**Our Ref: BR/63/18/PL**

**Development** First & second Floor rear extension to create 3 No. studio apartments  
**Location** 77 Aldwick Road Bognor Regis

EXISTING & PROPOSED
ELEVATIONS

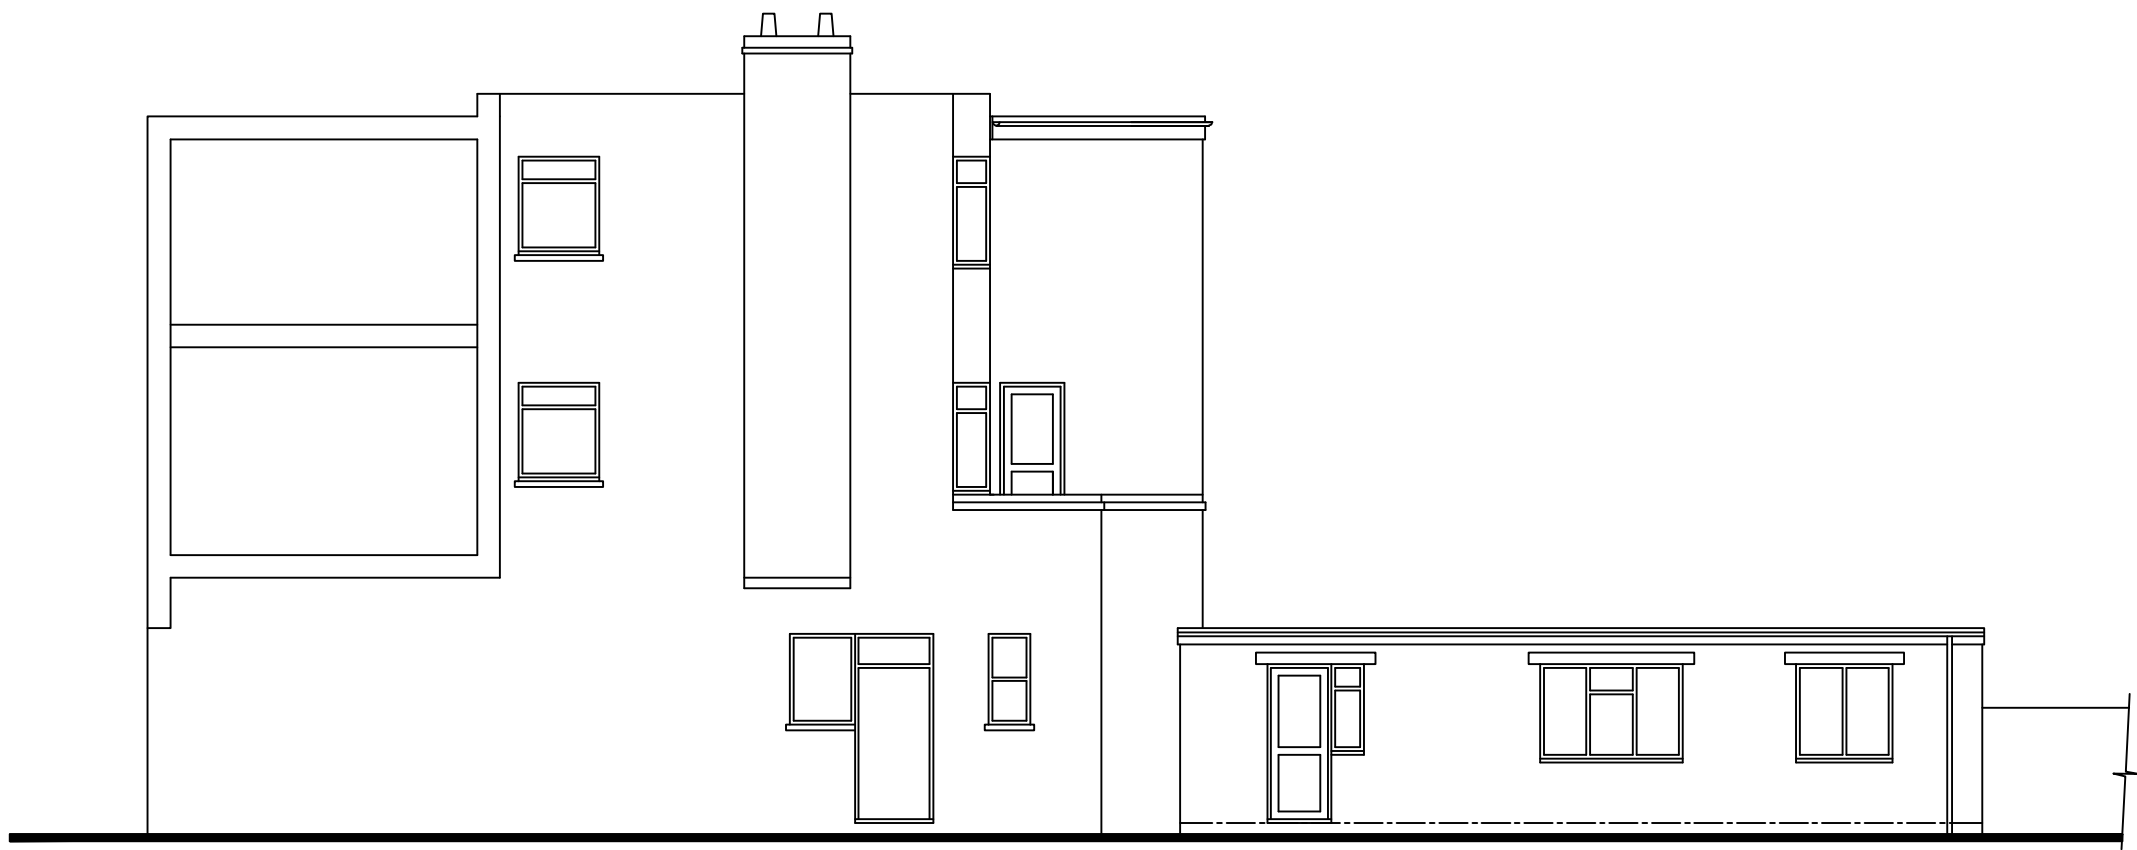
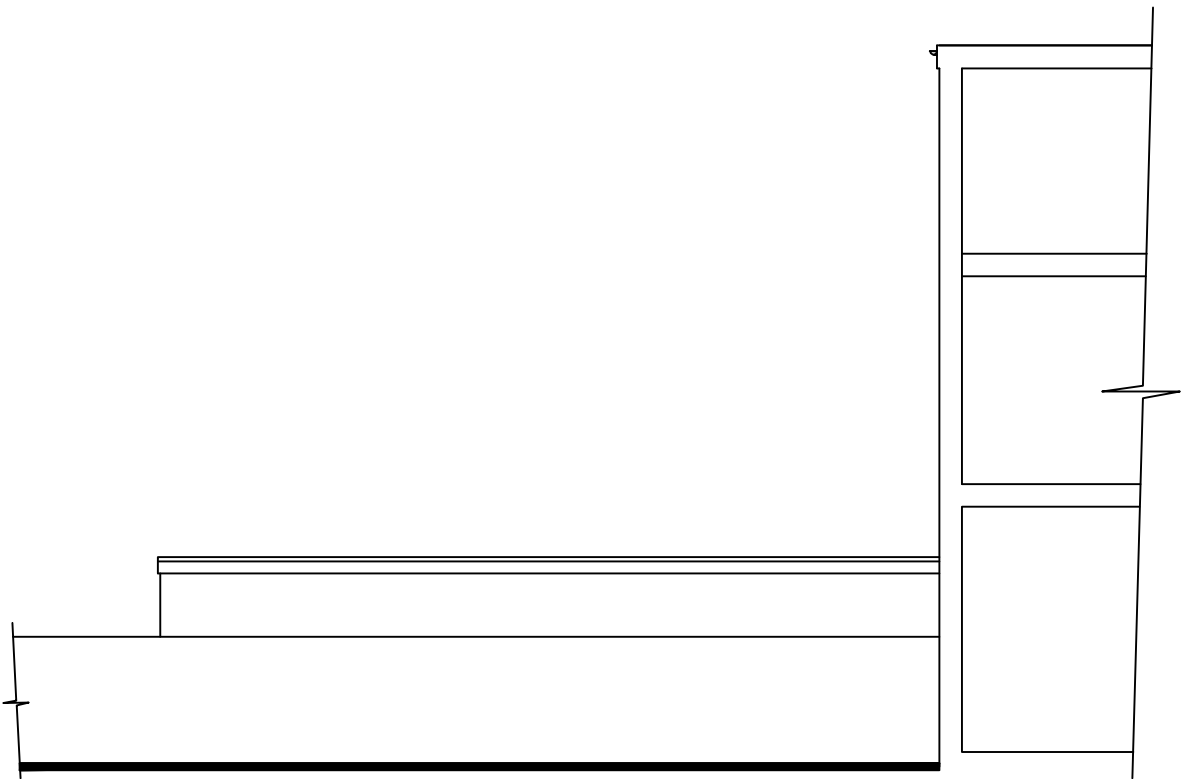
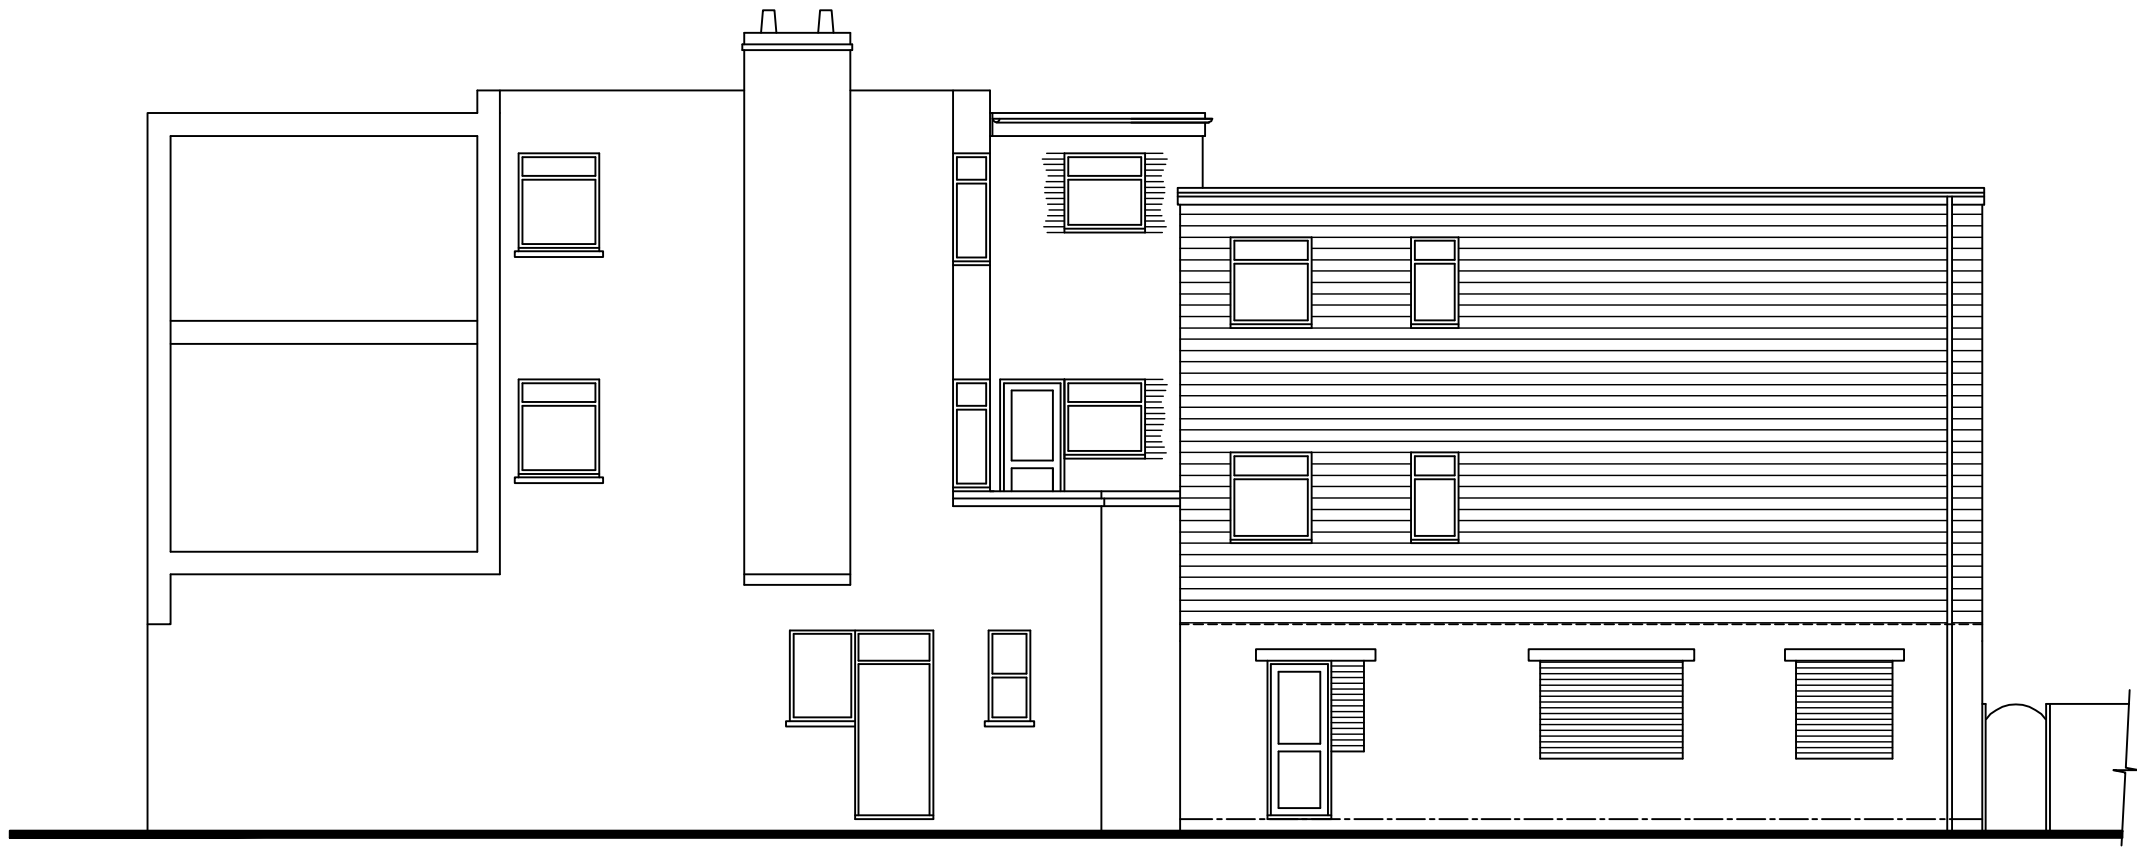
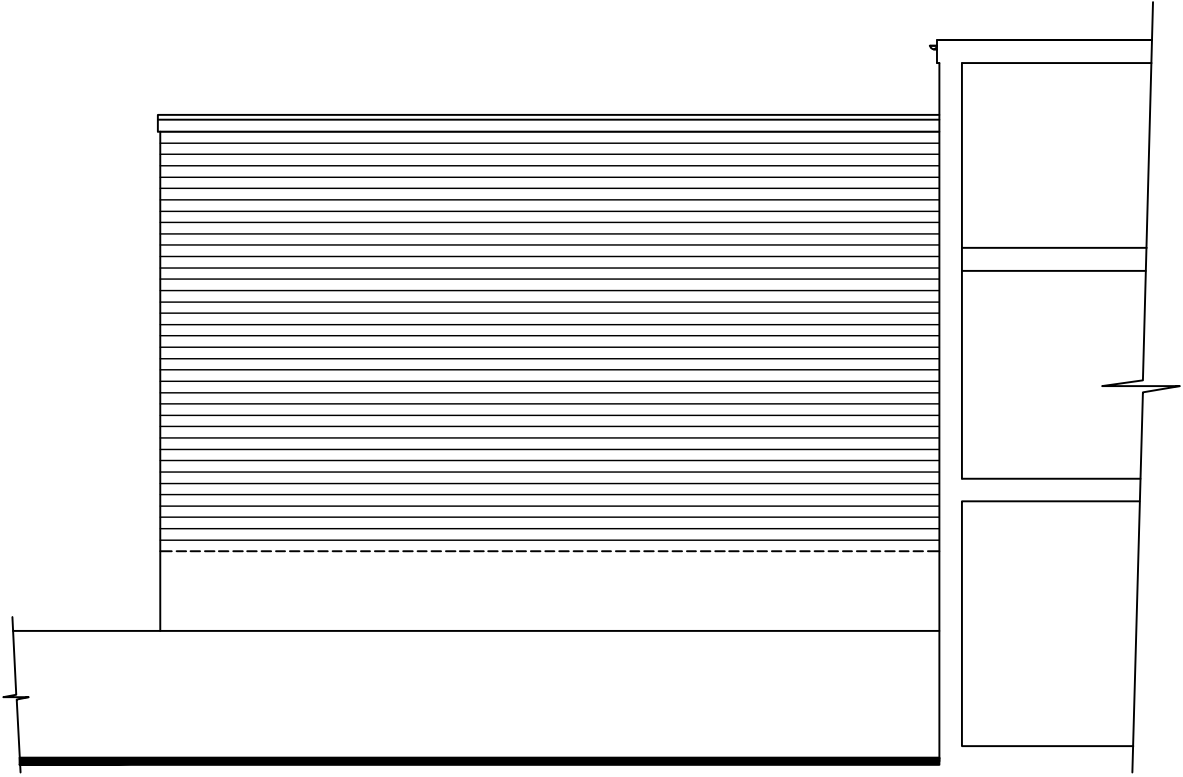
The existing and proposed ground floor plans and side elevations do not accord. Please amend accordingly.
